MP-2006/209/C

Proposed modifications to concept plan and a project application for:

Development

Construction of a new six-level retail centre (called as 'West Keira') associated with above and below ground car parking including necessary support structures for the erection in the future of two towers (one commercial, one residential) and their associated parking above the roof of the retail podium. Alterations and additions to existing 'Wollongong Central Shopping Centre', including a new eight screen cinema complex; and Interconnection of the West Keira with Wollongong Central across Keira Street via a tunnel and pedestrian bridge.

Figure 3-2: Modified access to basement car park

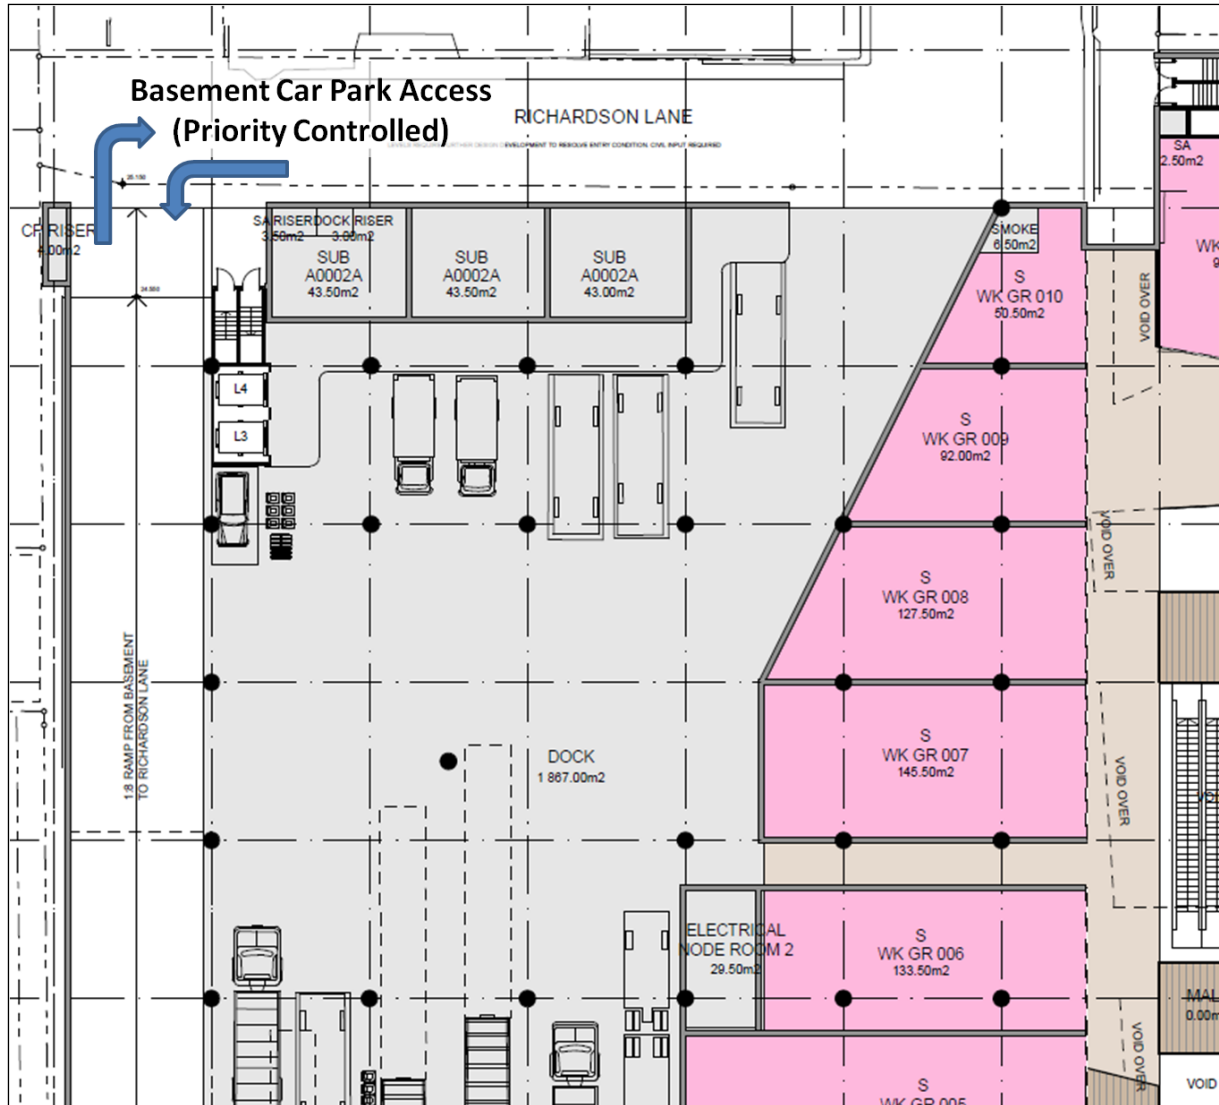
1. Richardson Lane is considered satisfactory to safely convey two way traffic. It currently conveys two way traffic. Private vehicles and service vehicles are adequately separated, so the leg of the lane to the west of the loading dock will be for cars only.

The current roadway has a width between 6.0m and 6.6m and part of it lies within the property boundary. The road reserve width is approximately 5.9m. This road reserve width is adequate for a lane way use. Given the anticipated traffic volumes to use the car park access, a road width that complies with current standards is needed. The absolute minimum lane width required by Austroads is 3.0m. Council recommends that the developer provide a finished road width in Richardson Lane of 6.0m kerb face to kerb face to comply with the minimum standard set in Austroads 2009 Guide to Road Design.

2. The driveway entry in Richardson Lane allows cars to pass each other while simultaneously entering and exiting the ramp.

It is recommended that this is confirmed by the consent authority in accordance with clause 2.5.2c of Australian Standard AS2890.1 (2004) - Off-street car parking which provides a turning path guide for such situations.

DRAWING TITLE:
WEST KEIRA
EAST FACADE DETAIL ELEVATION
SECTION

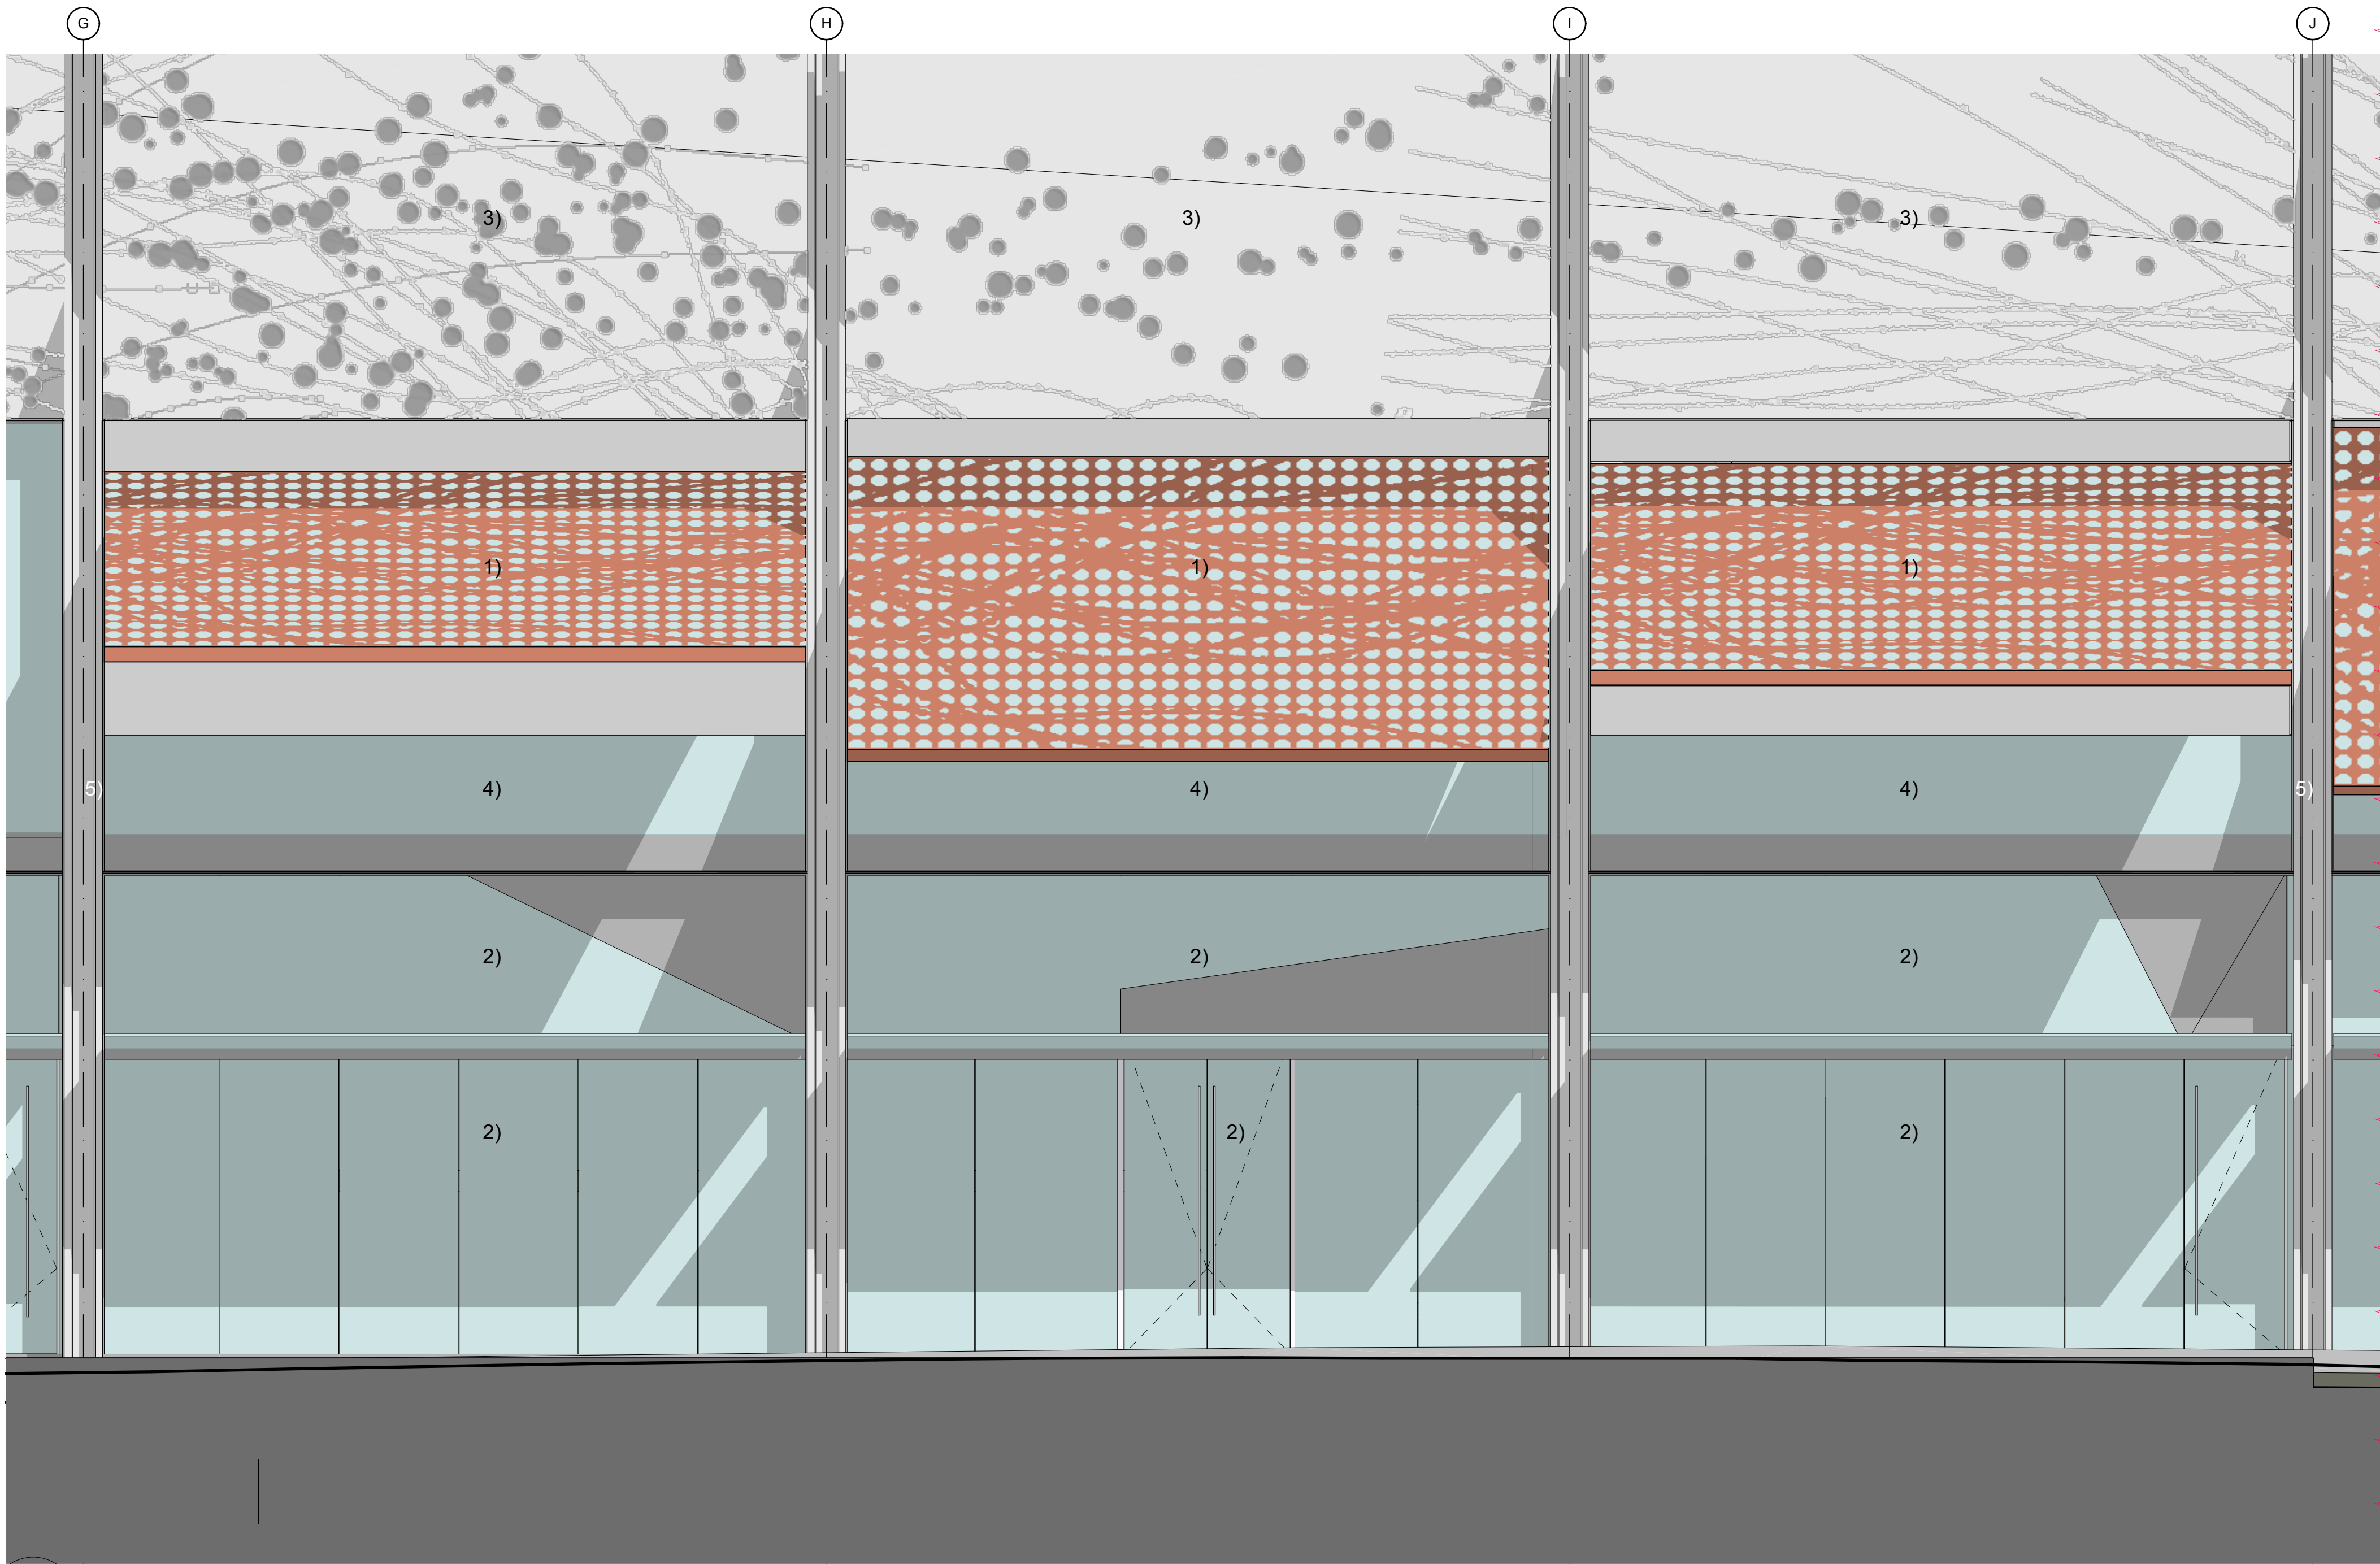
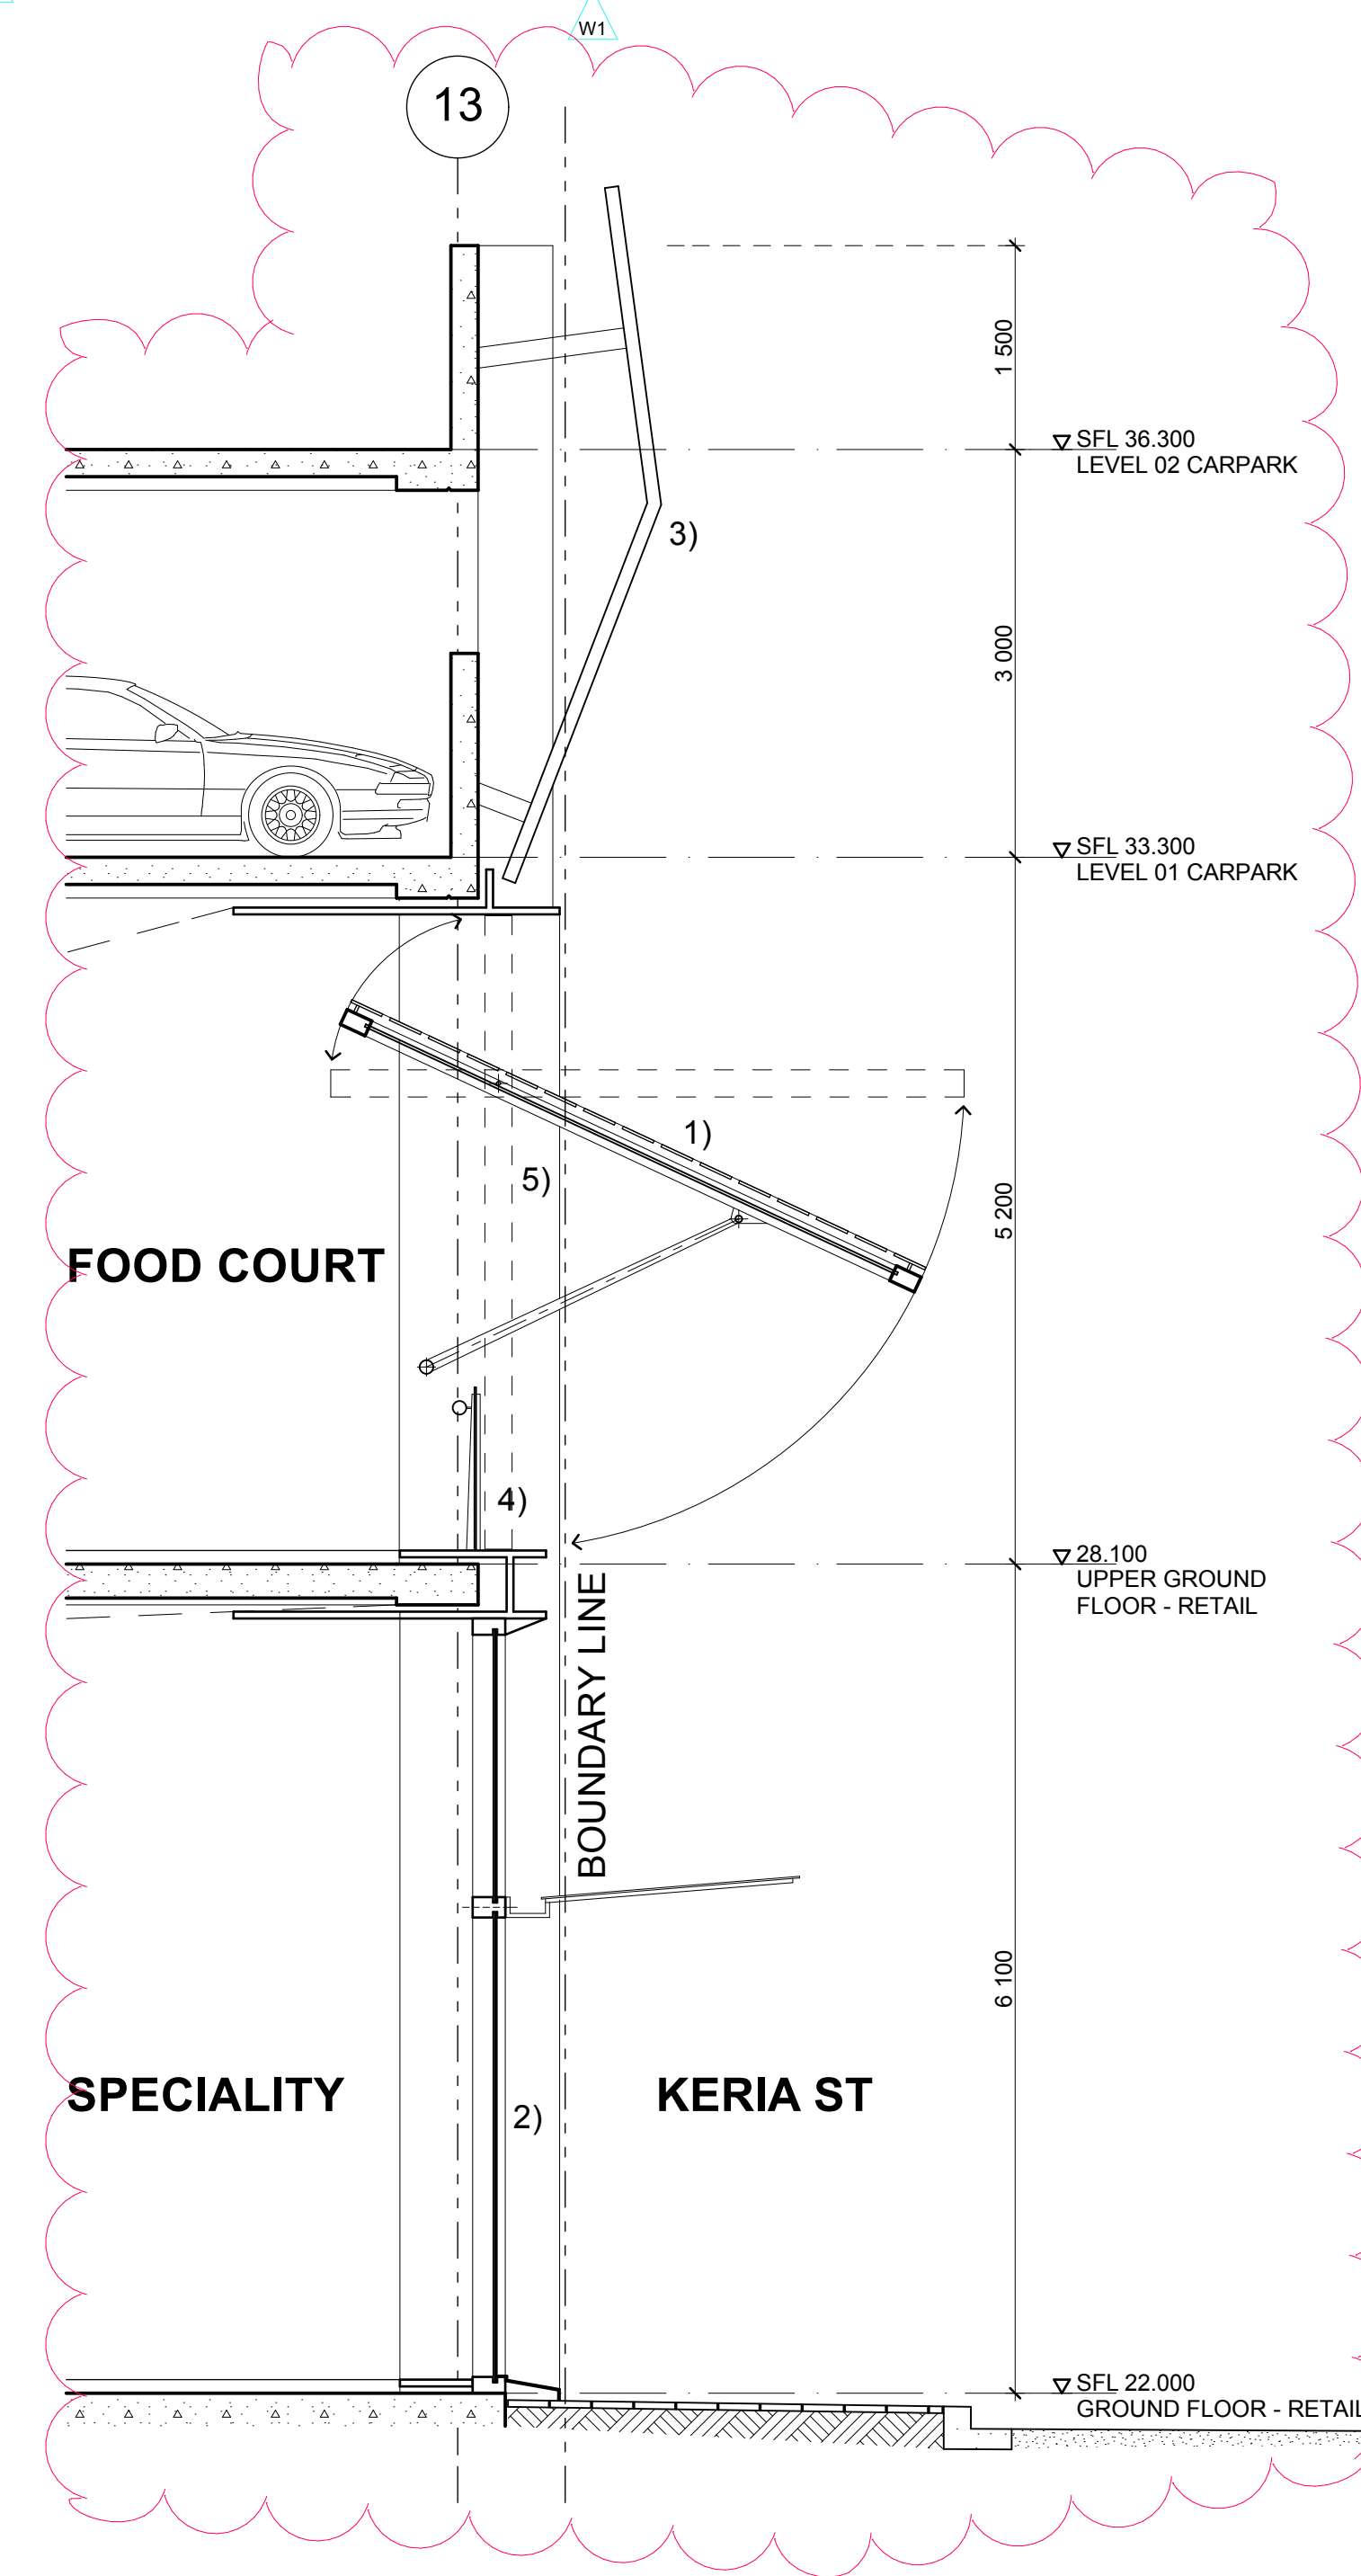
3. Discussions with the RTA and Wollongong Council regarding Keira Street bus stops are continuing. GPT is supplying the RTA and Wollongong Council with plans showing footpath dimensions and infrastructure within Keira Street, as well as cross sections with possible solutions. GPT's view is that the kerbside lane of the northbound carriageway of Keira Street can be used as a bus stop by the provision of a "bubble" treatment with widened footpaving. This treatment works successfully in other town centre locations. Both sides of Keira Street could potentially have footpath widening with bus stops and taxi ranks. An agreed outcome may well be an interim measure where a bus stop without any shelter is maintained on a temporary basis until a more permanent solution is agreed.

This item was discussed with RTA and GPT representatives at a meeting held at the Council Administration Building on 28 October 2011. No footpath widening works are able to be supported at this time due to a number of issues requiring further consideration; however Council is willing to work with the RTA and GPT on investigating such proposals.

In relation to the current proposal, Council does not consider the provision of a shelter necessary where an awning is provided that gives protection from the weather. In this regard the proposal includes a 1.2m minimum setback from the kerb to the awning resulting in an awning width of 1.79m. The RTA Road Design Guide states "In general, shop awnings are to be set back a minimum of 600mm" to cater for potential obstruction of vehicles on the road (clipping of mirrors or sloping trucks etc) so there may be potential to reduce the setback requirement set out in Council's DCP to 600mm to allow for a wider awning to be provided.

In addition to the awning provision it is recommended that the proposal or a condition of consent include the provision of a bus stop sign in the form of a plinth, bus zone signage and allowance for the installation with four minimum 1.9m long bench seats adjacent to the bus stop on the western side of Keira St for the use of bus patrons. Any alternatives to this arrangement shall be to the satisfaction of Council and the RTA.
